## Response to Newcastle City Council's Submission

### **RE: Response to Submission from Newcastle City Council on Mixed Use Development (SSD 8019 MOD1) at 21 Honeysuckle Drive, Newcastle NSW 2300**

LEVEL 01 - FLOOR PLAN

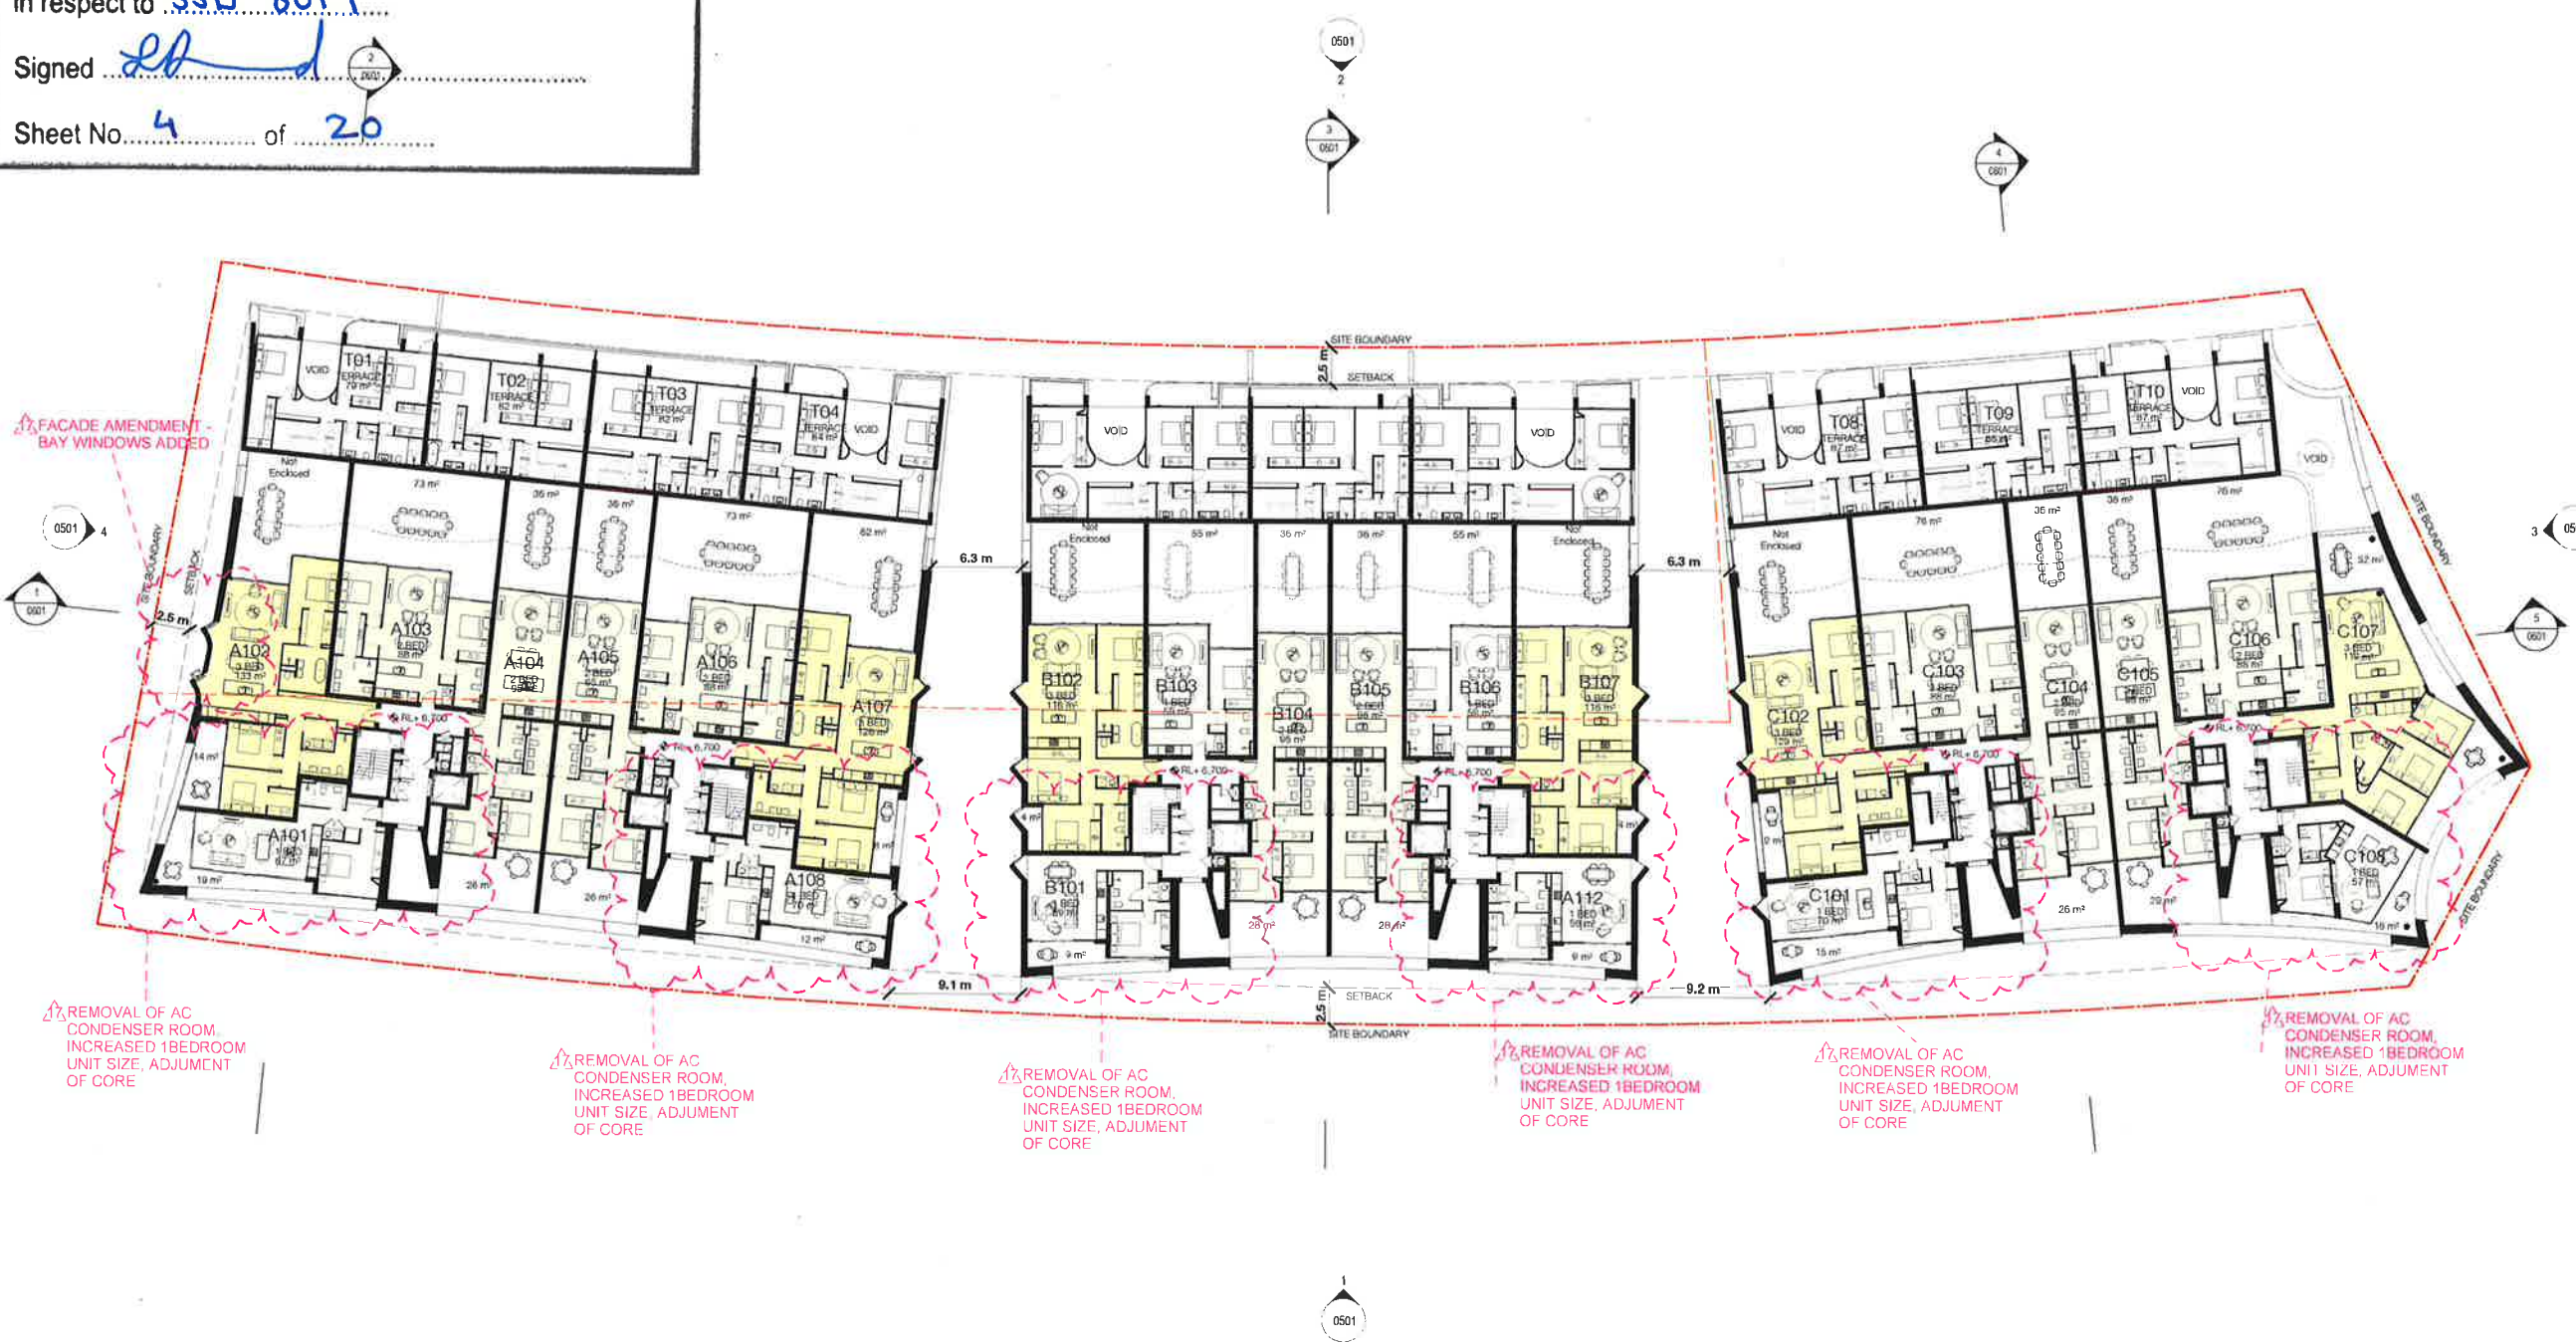
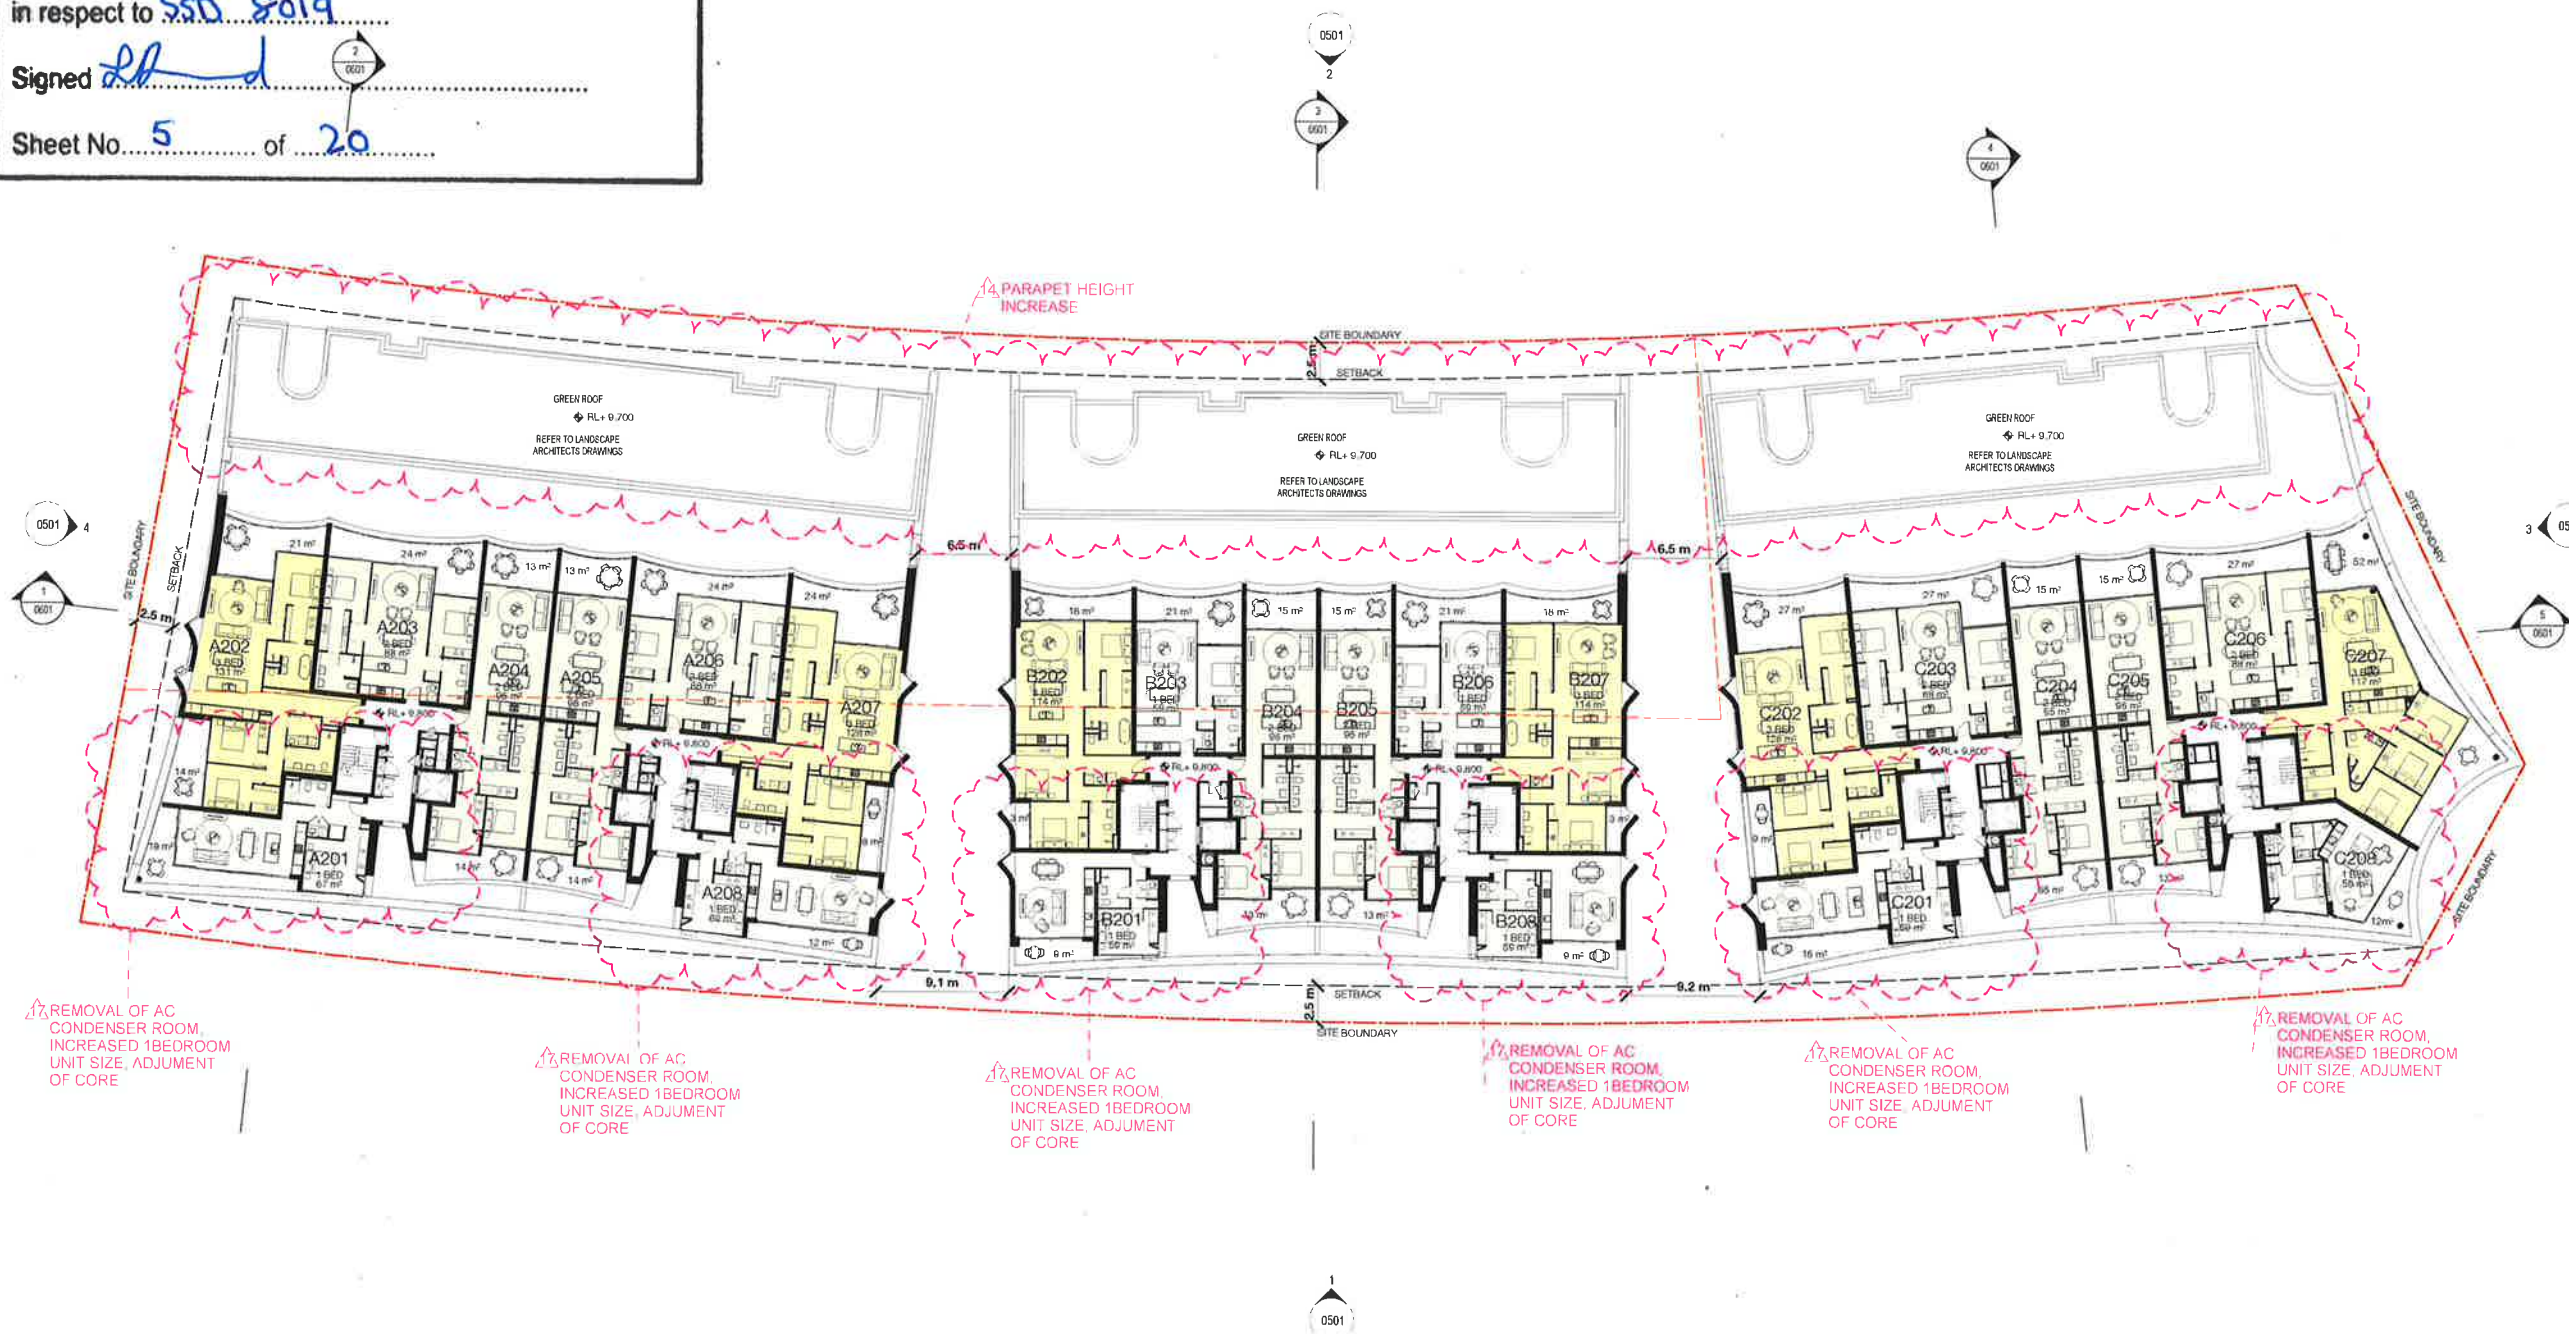
*In addition to the proposed design modification indicated in the SEE, the submitted plans include amendments to commercial tenancy balcony on the ground floor plan and the inclusion of bay windows to the western elevation at level 1 which have not been acknowledged.*

The windows on level 1 western façade of western building, and the amendment of the balcony layout to the ground floor commercial tenancy are minor and considered to be generally in accordance with the original approval.
